Response to Planning Application

From: Arun District Council Greenspace

Application ref: P/132/20/RES

Location: Land north of Hook Lane Pagham

Project	Hook Lane, Pagham
Drawing	Site Layout
Client	Hallam Land
Job no.	HALL200505
Dwg no.	SL01
Author	AS
Status	PLANNING
Client ref.	
Date	June 2020
Revision	A
Scale	1:1000 at A1
Office	Romsey

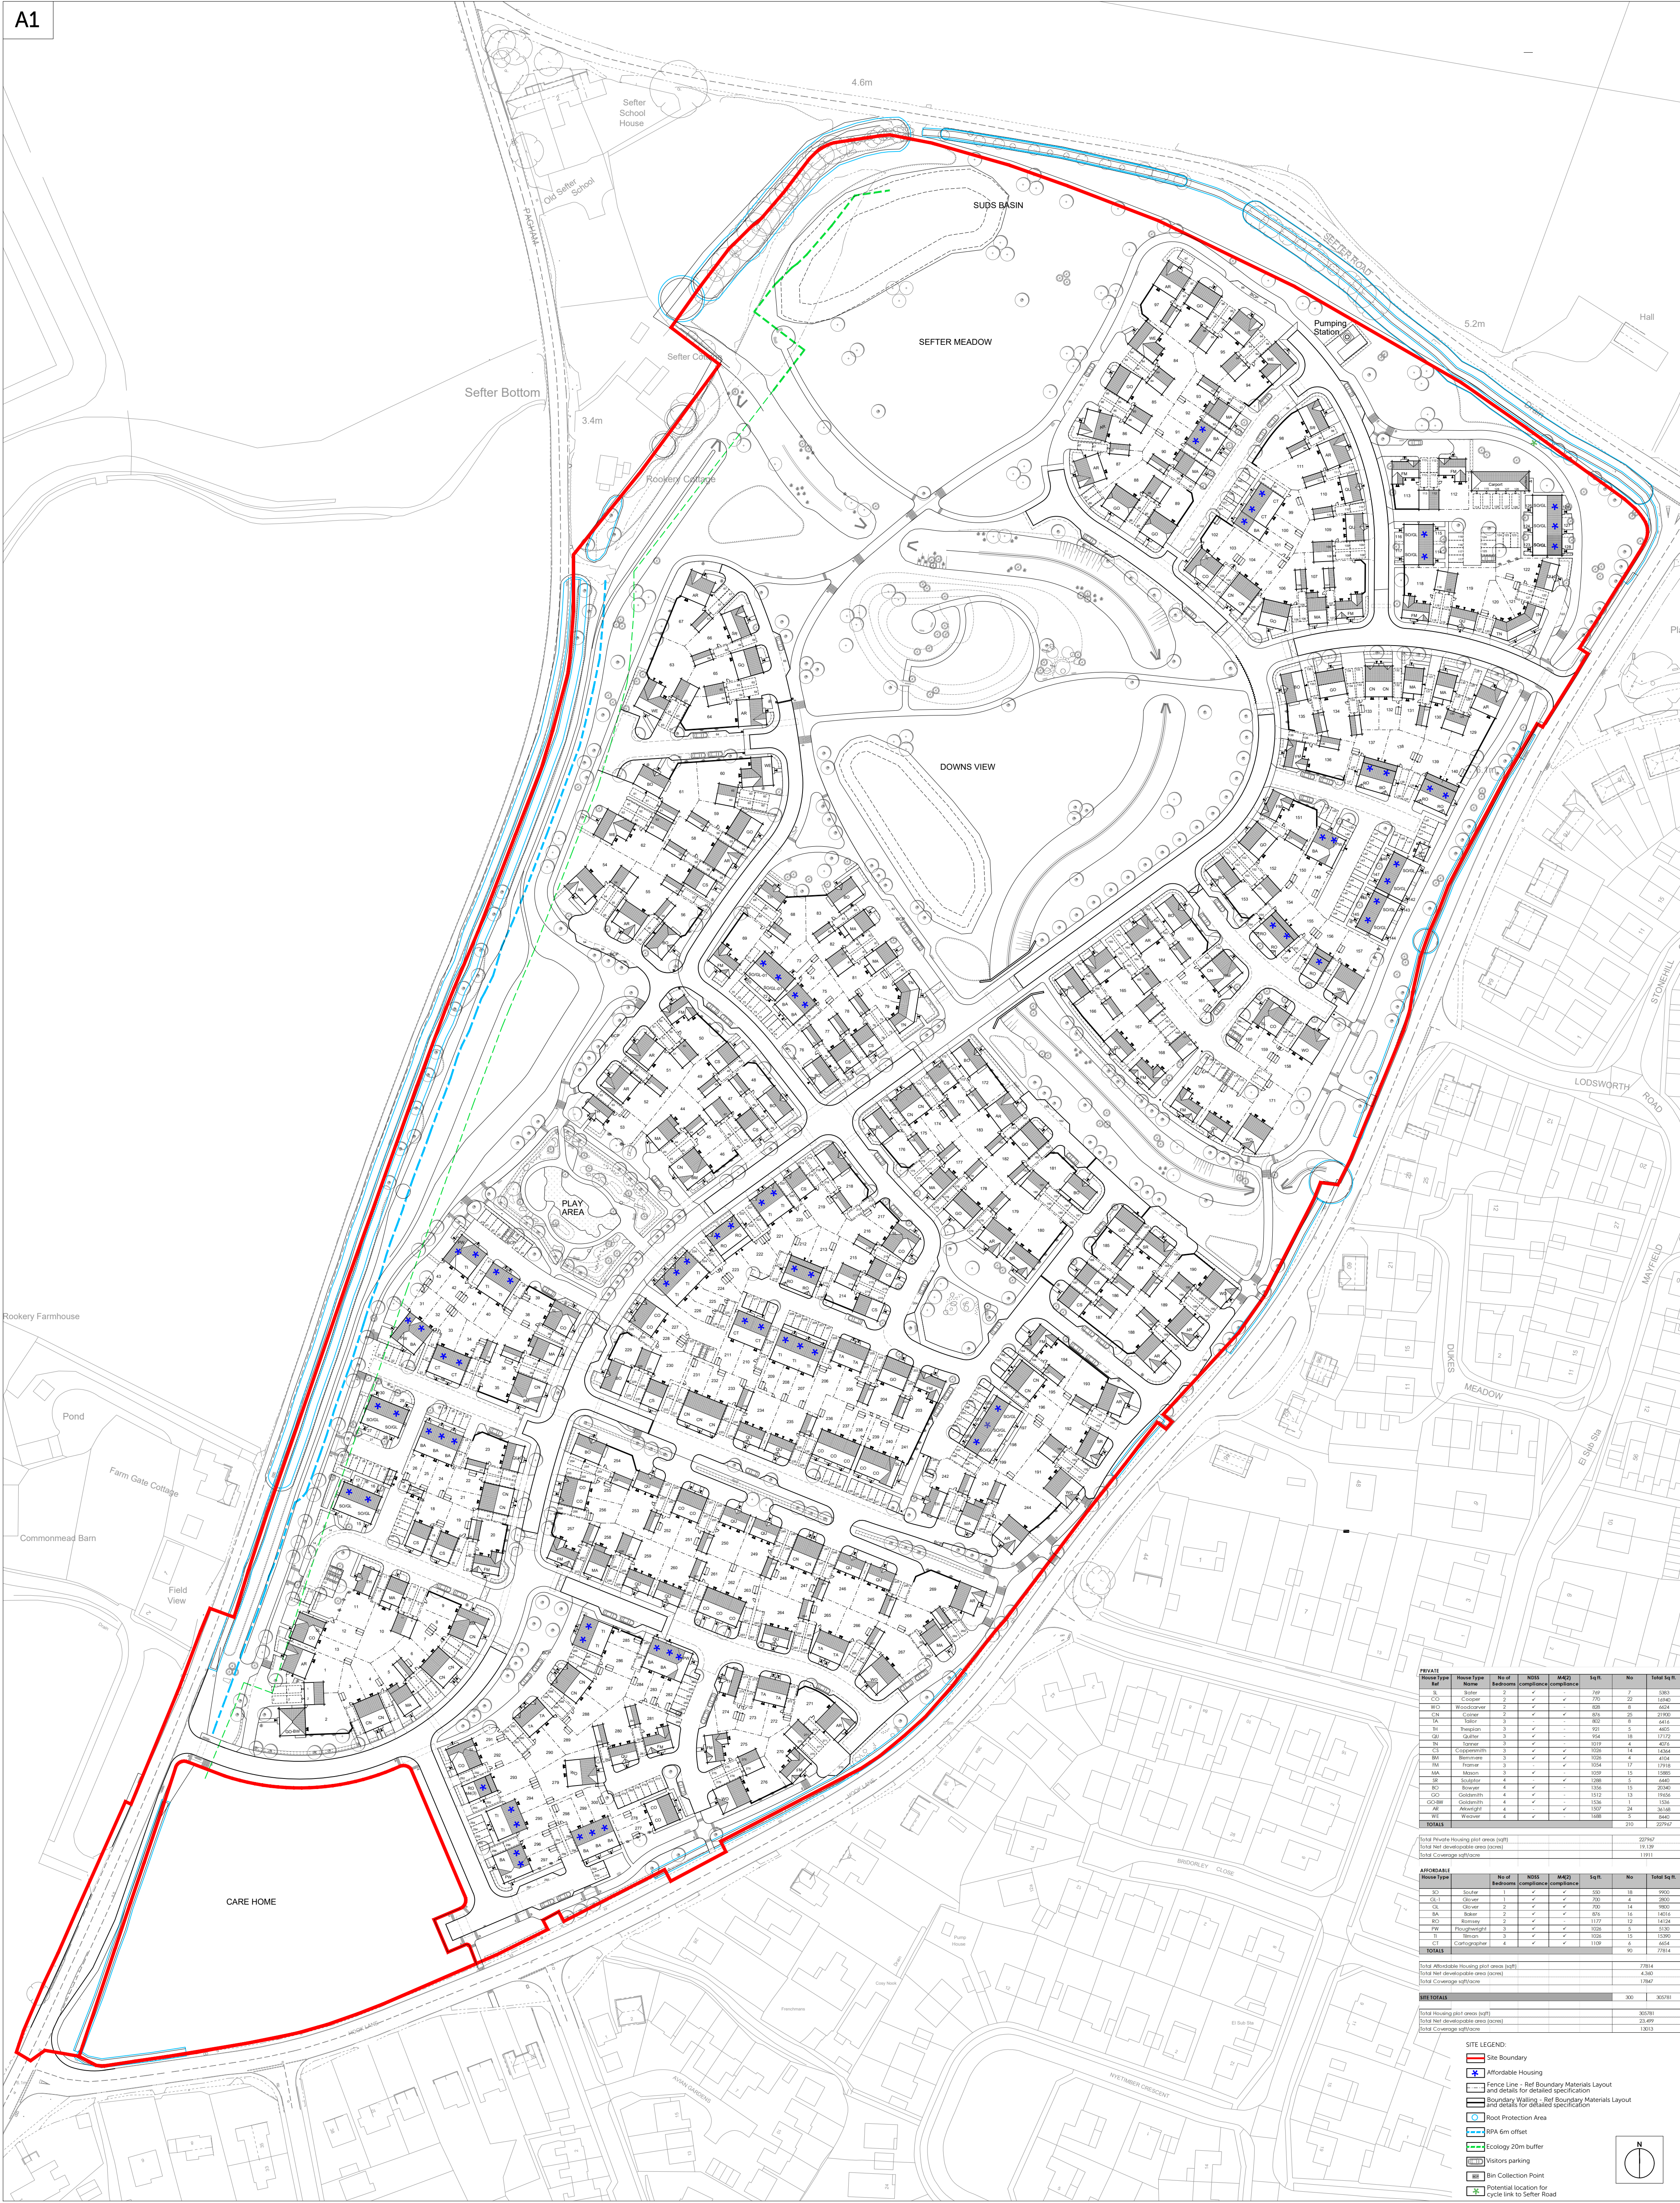
The green east west continual corridor between Sefton Meadow, Downs View and Rife Green, has due to layout been bisected by the road. It will be important therefore for establishment of trees to allow 'hop overs' to ensure continued habitat connectivity albeit at a canopy level.

Areas of the POS area appear to the periphery of the site where buffer zones incorporate the existing tree presence and the SuDS features have been located. The layout would appear to differ slightly from that set out in Original Design Concept Landscape Masterplan Option B dwg 167/P/003/Rev D where the play area was shown in a different location and not with the central Downs View Area.

Confirmation needs to be provided that the quantum of POS excluding SuDS areas still meets the minimum requirements set out in our Open Space, Playing Pitches, Indoor and Built Sports Facilities SPD Jan 2020

The original Design Concept at outline stage showed a cycle route running across the middle of the site and through the central green area. This appears to have now been omitted from the scheme. It needs to be demonstrated how the cycle connectivity is being catered for providing links to the wider site and beyond. The use of Hoggin for pathways and also for main routes through POS areas need to consider all year round pedestrian and wheeled user access. The use of tarmac in the more highly trafficked areas would be seen as more appropriate in these locations.

Recommend further detail to be provided confirming quantum of POS areas considering and excluding SuDs areas, Play area ELEAP and LAP provision to be detailed and submitted for approval, maintenance specification and liability to be detailed detail following outline approval P/134/16/OUT.
